K/19/19/HH – Little Tangle, Middle Way, East Preston BN16 1SB

We write in connection with the planning application K/19/19HH.

Proposed Section AA

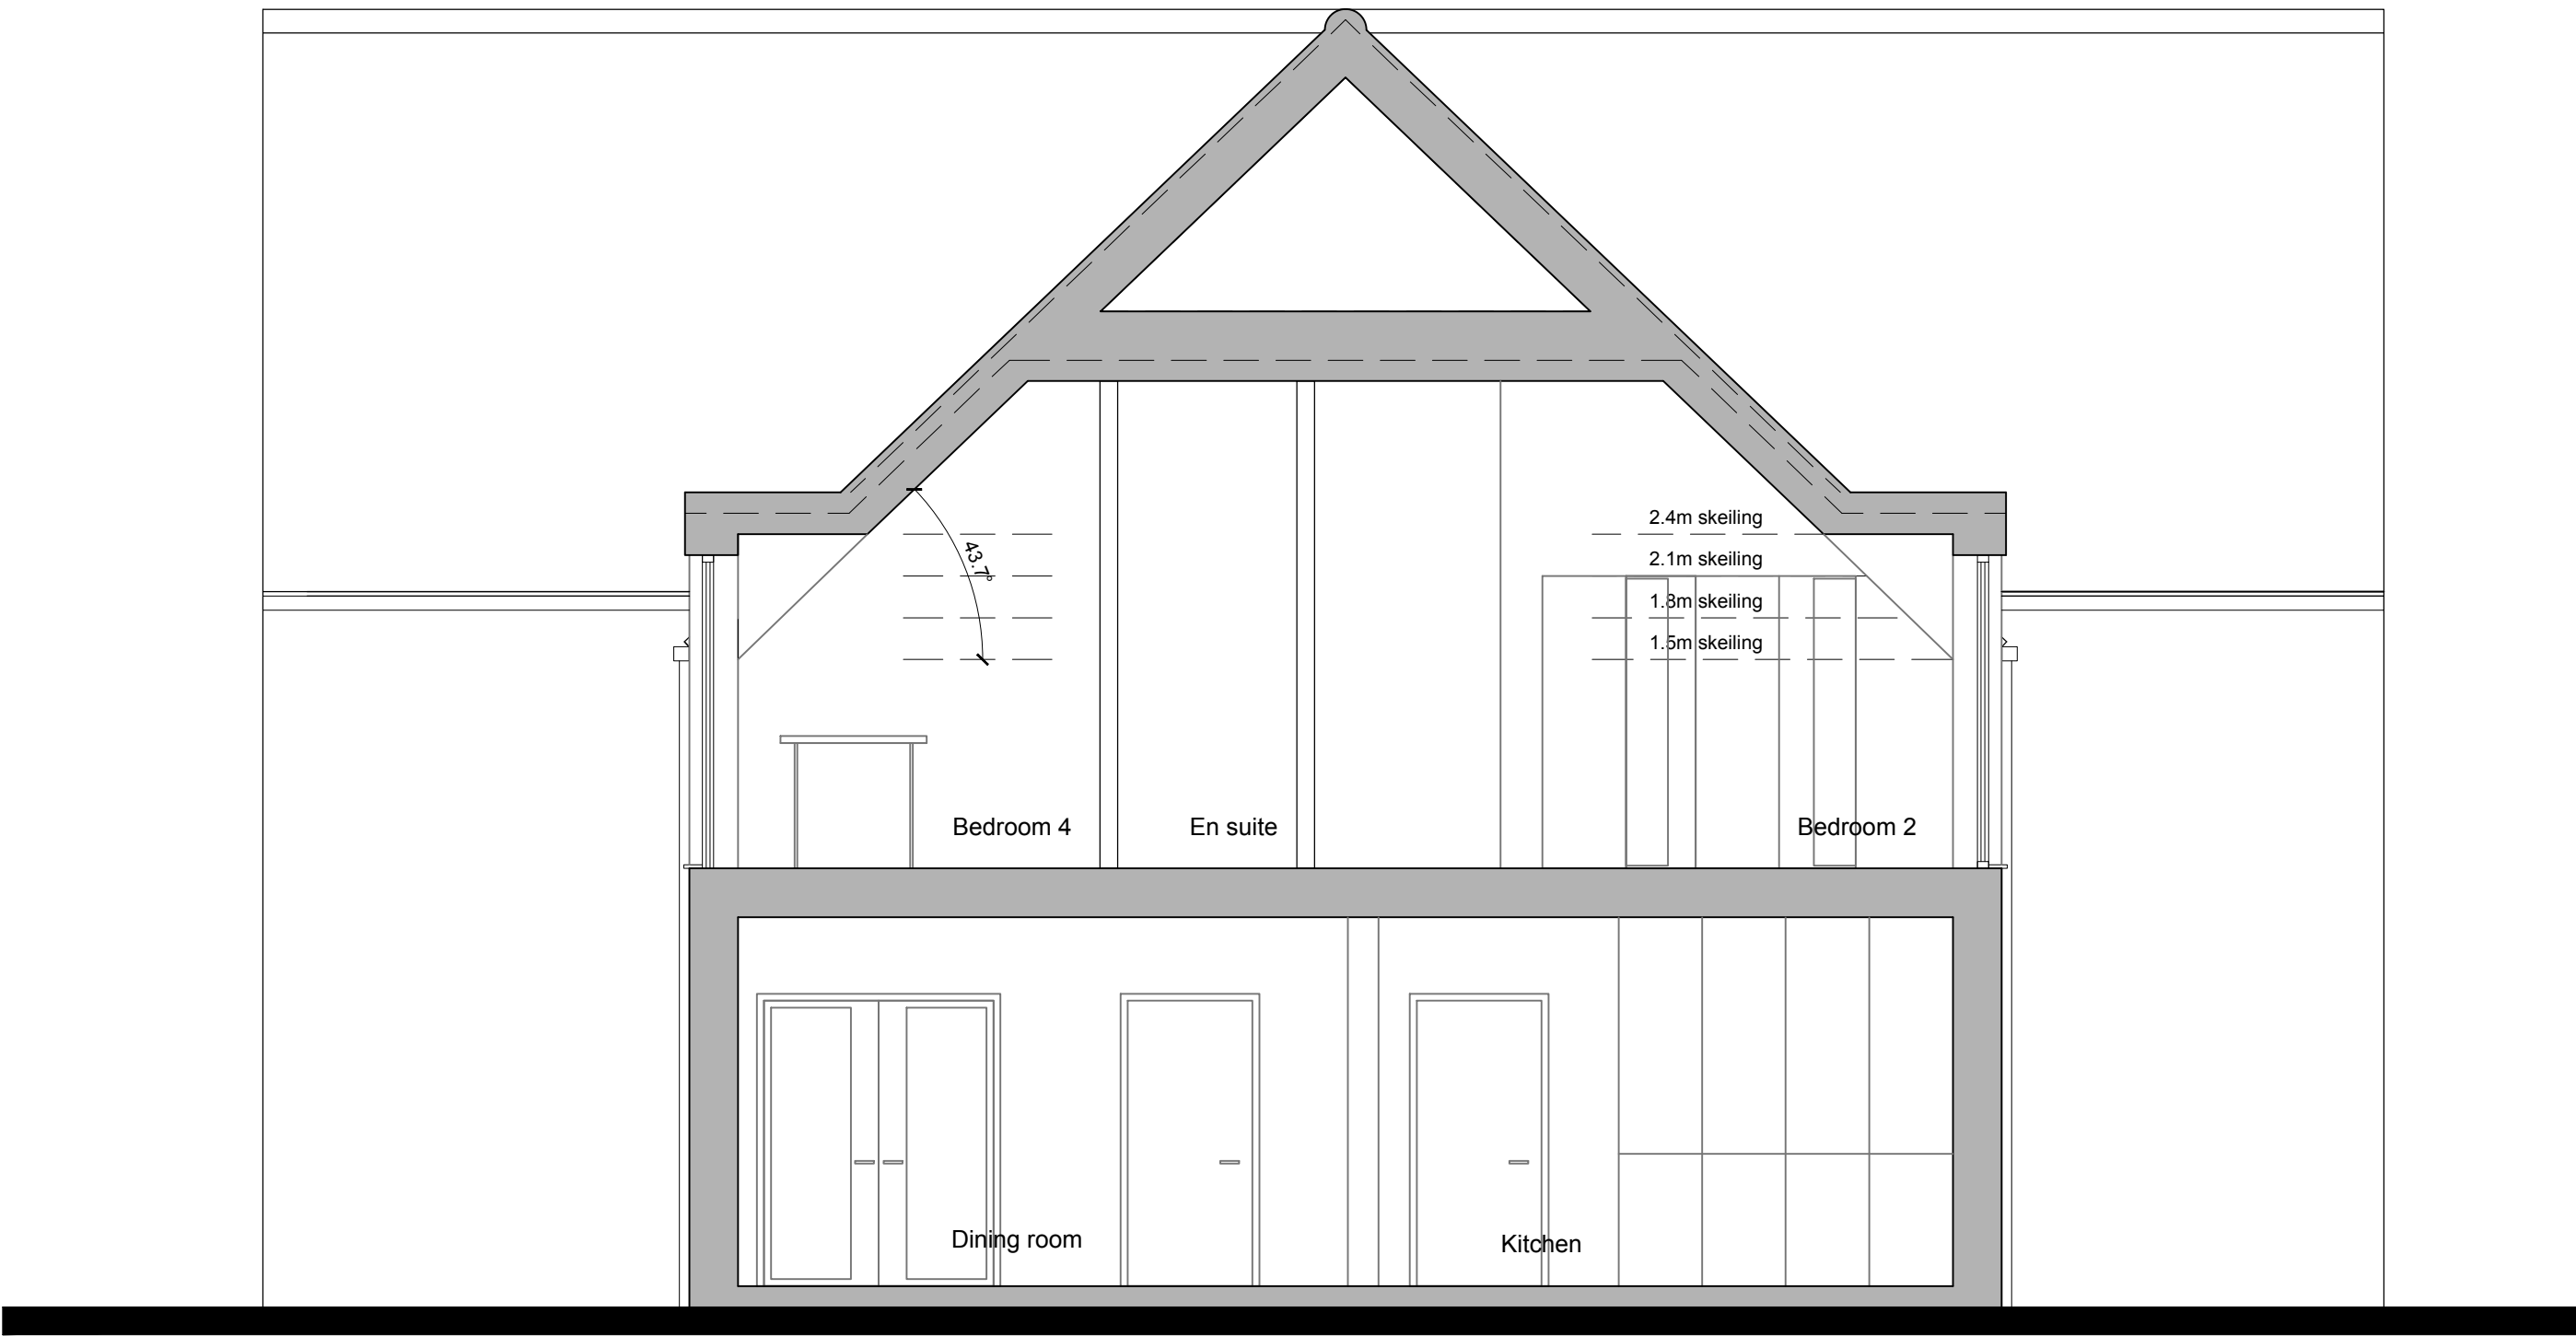
1. Little Tangle is in fact a bungalow that has accommodation in a small part of the roof area rather than a detached house. Consequently, whilst the planning application maintains the overall m2 footprint on the ground floor, it represents what appears to be in the region of a 2-2.5 times increase in the overall mass of the building by virtue of the first floor alterations.
2. The building ridge height is currently c12m and the proposed ridge height is c15.4m, an increase of 3.4m (a 28% increase). The Poynings (the east neighbour) ridge height is 13.4m. This is seen clearly in the document Proposed North and South Elevation 6702.20P1.

For the planning rules to be applied consistently the maximum ridge height for this development, as an extension, should be c11.5m.
